Application for removal or variation of a condition following grant of planning permission. Town and Country Planning Act 1990. Planning (Listed Buildings and Conservation Areas) Act 1990

Demolition of existing Saw Mill and erection of 5 no. apartments and 9 no. houses with amenity space, integral garages and associated parking. (Part retrospective)

Application reference number:	<input type="text" value="2012/1122"/>	Date of decision:	<input type="text" value="14/01/2013"/>
-------------------------------	--	-------------------	---

Condition 2 - Omit approved drawings 10/064/100A, 101A, 102A, 104, 106 and 107 and substitute attached drawings 10/064/100B, 101B, 102B, 104A, 106A and 107A.

Drawing No: **101**                      Drawing Title: **Proposed First  
 Floor Plan**

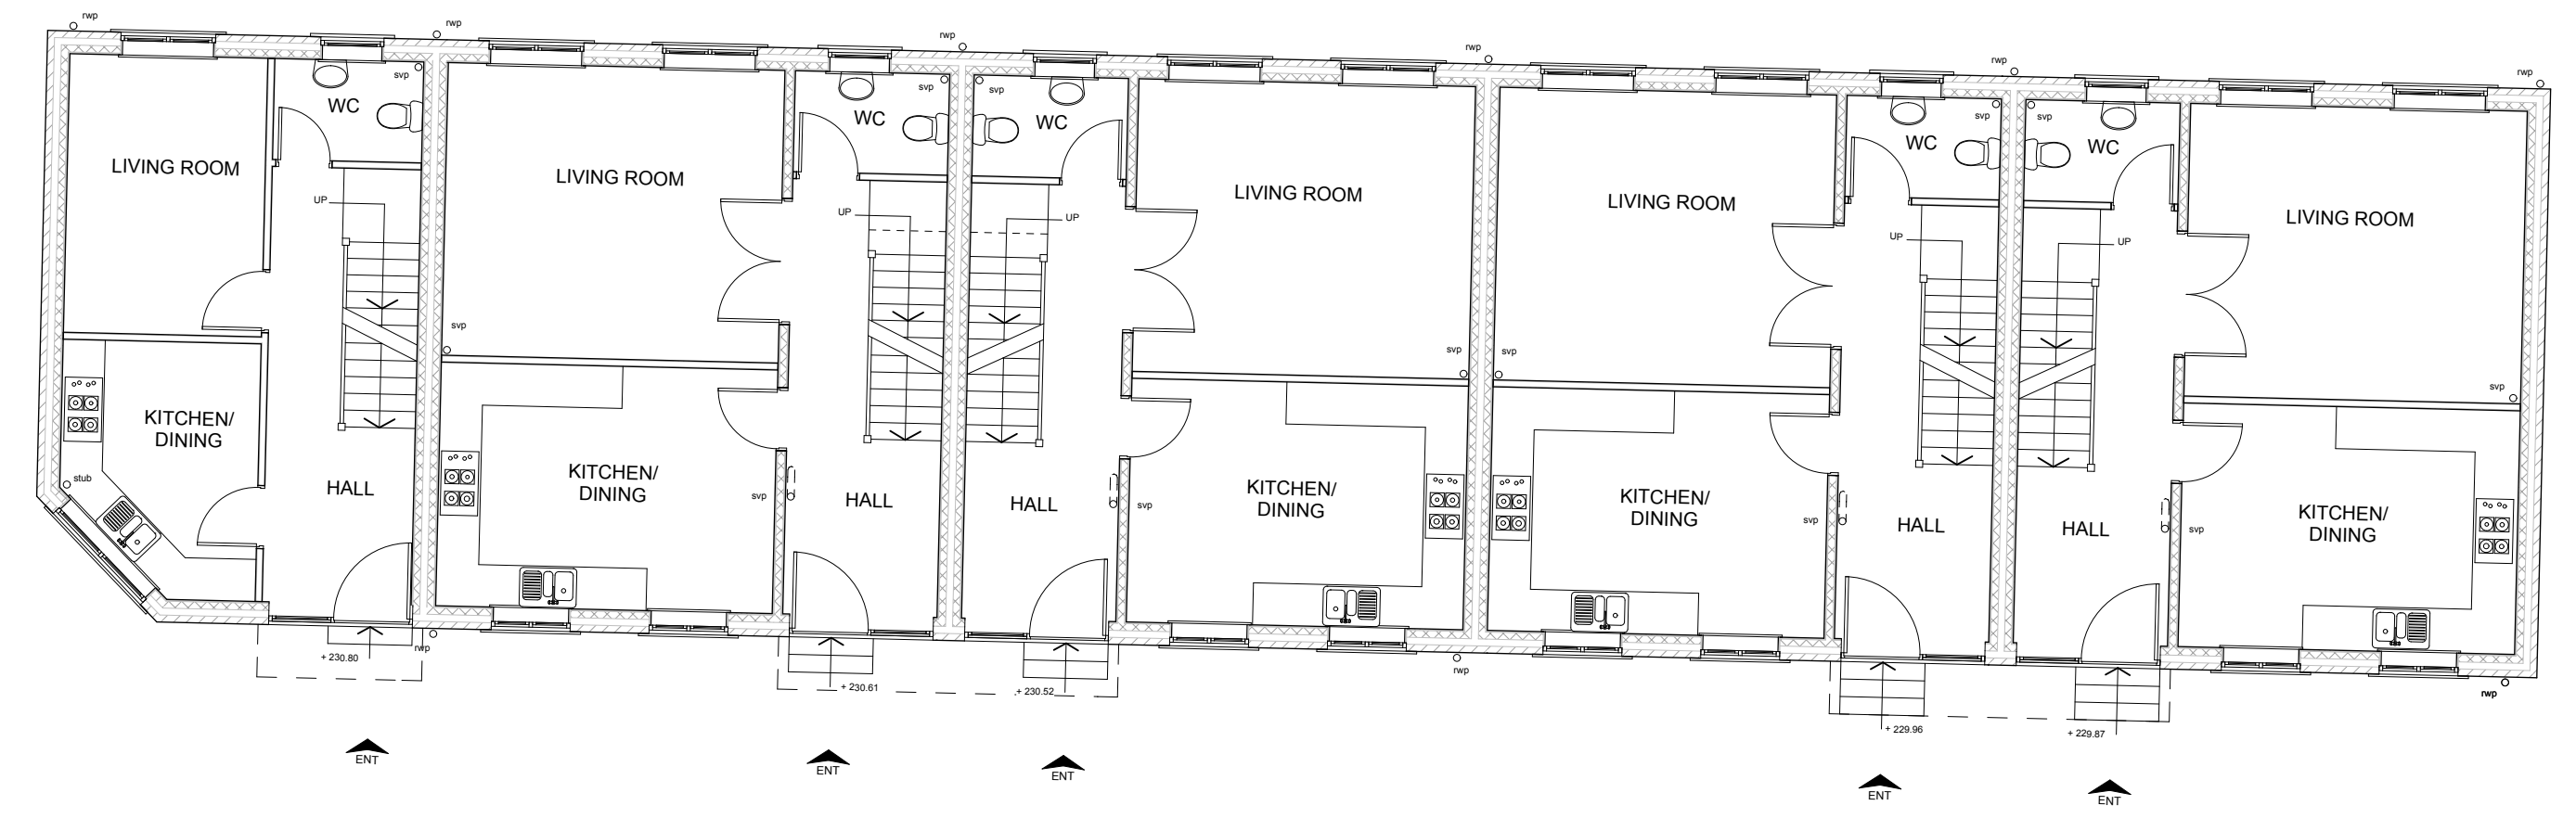
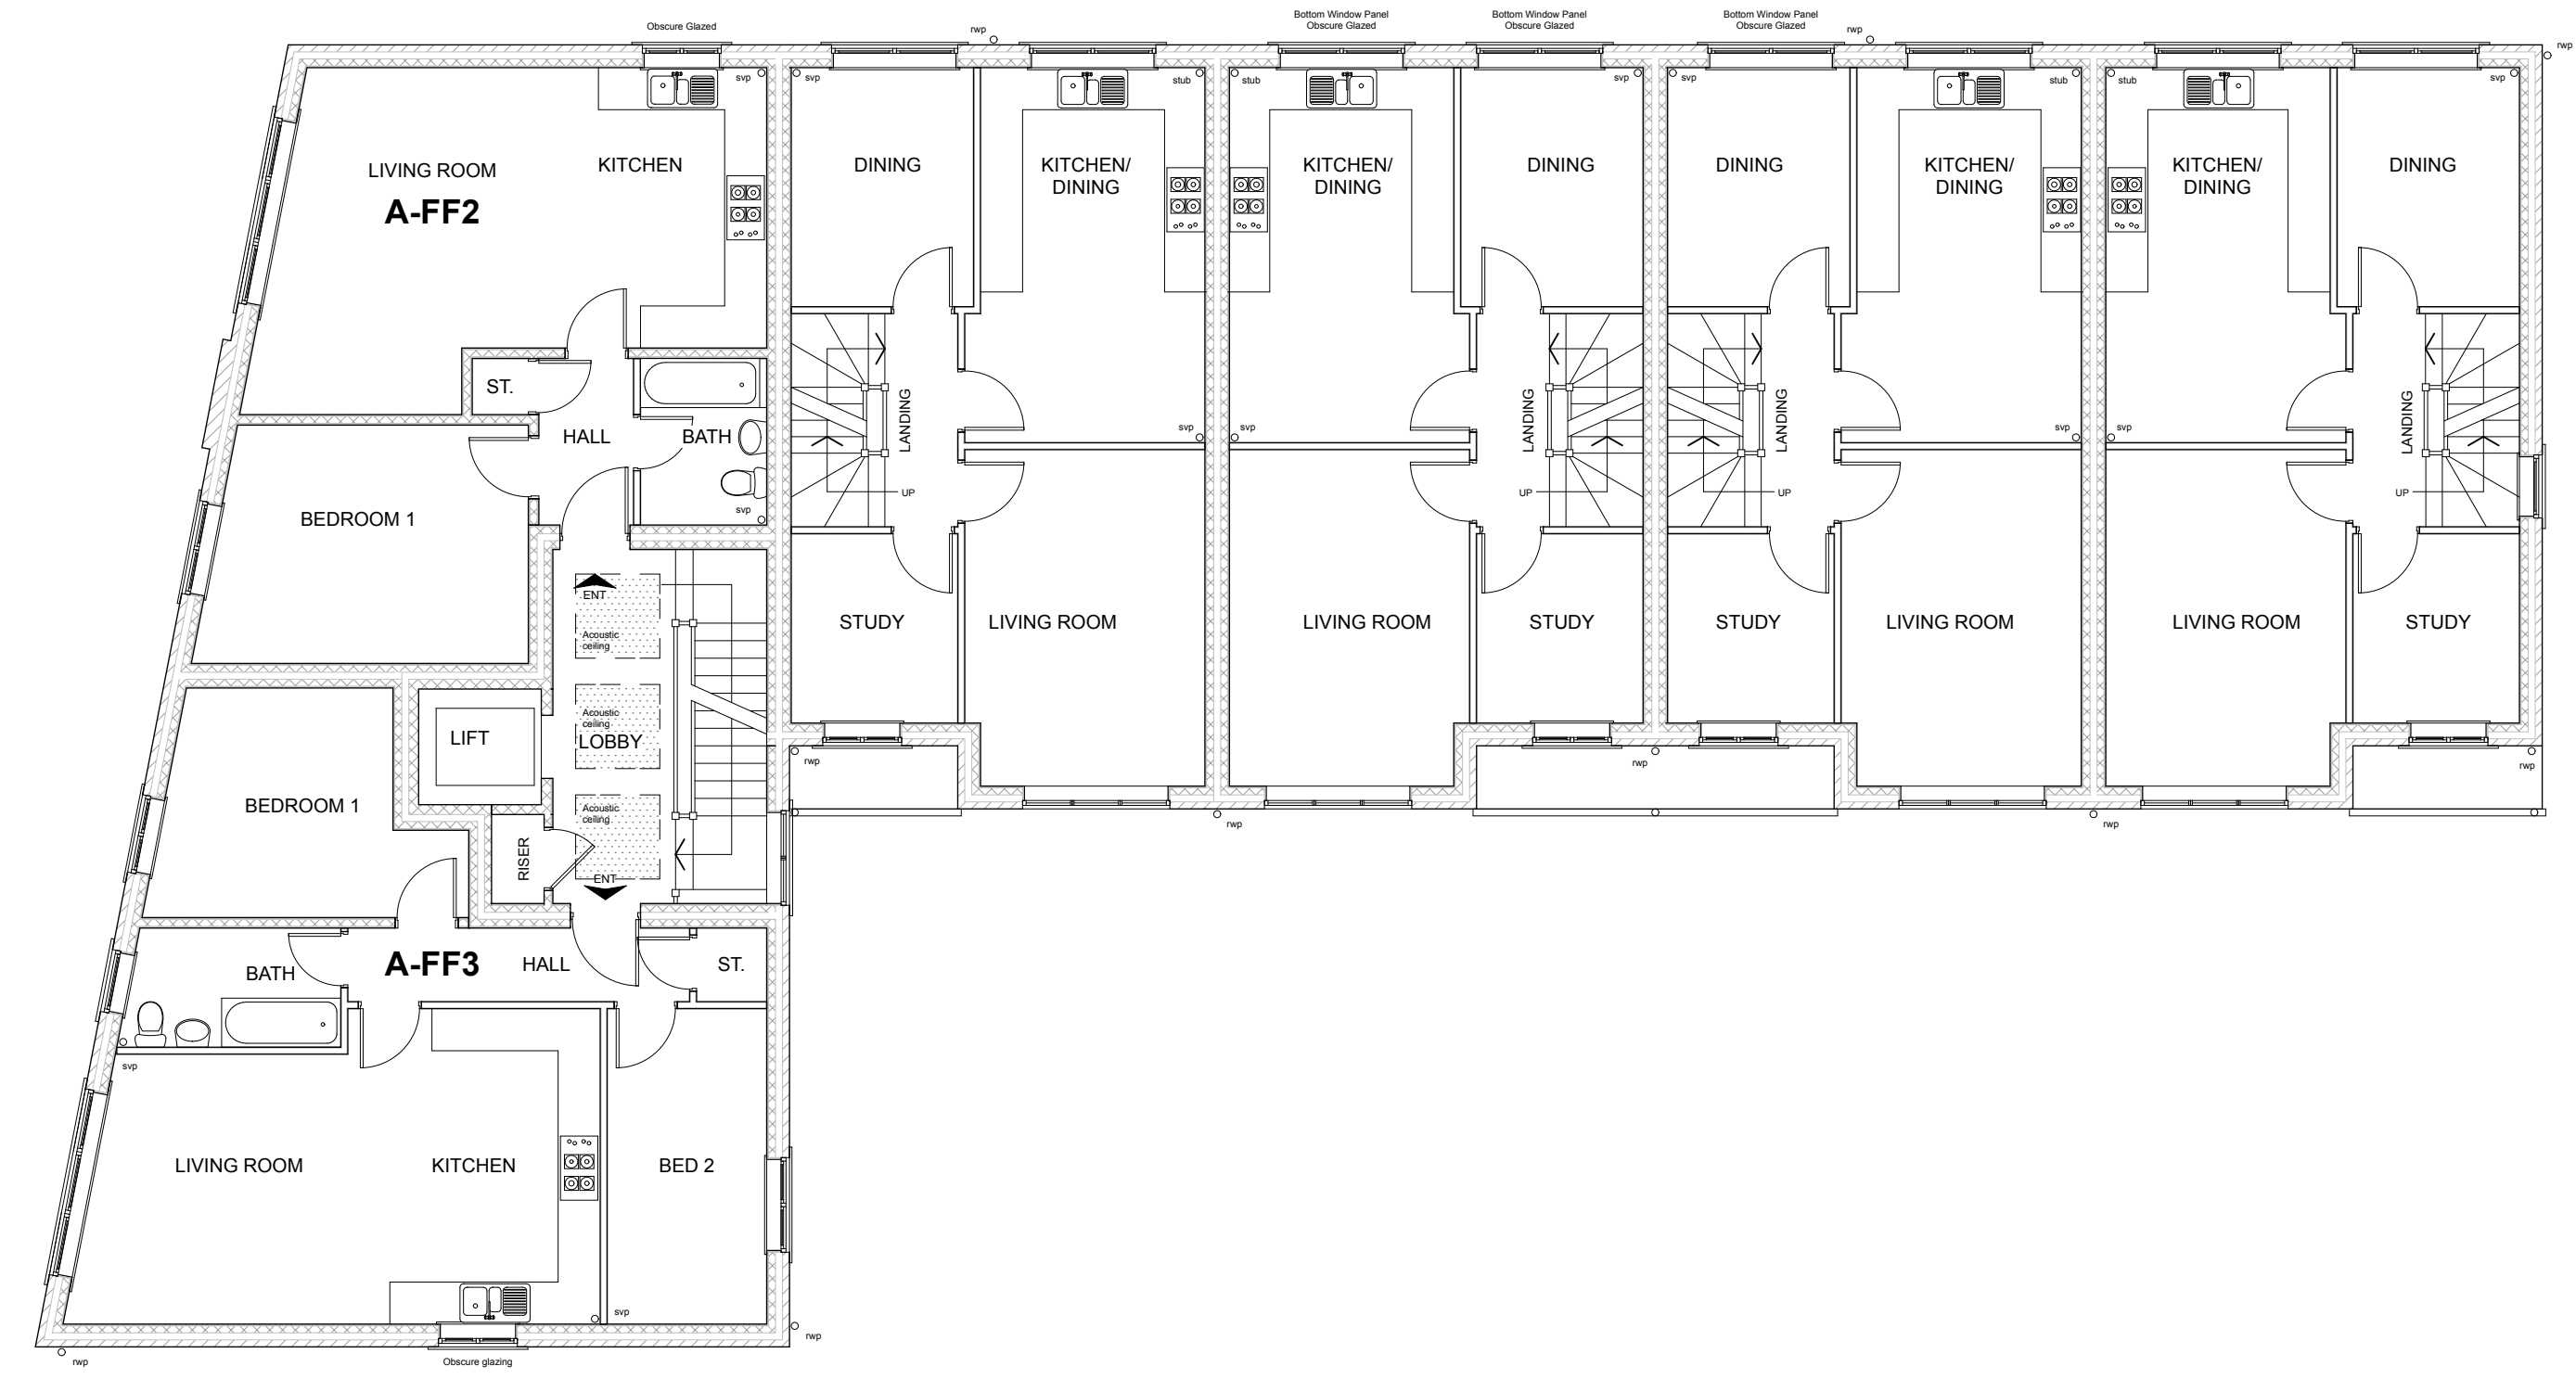
External entrance to block A Apartment lobby requires repositioning to comply with Building Control / Fire Officer requirements.
Recessed entrance doors to block B off The Green omitted in order to obtain a New Homes Warranty on the design, flush door / sidelight with canopy over more in keeping with the locality.
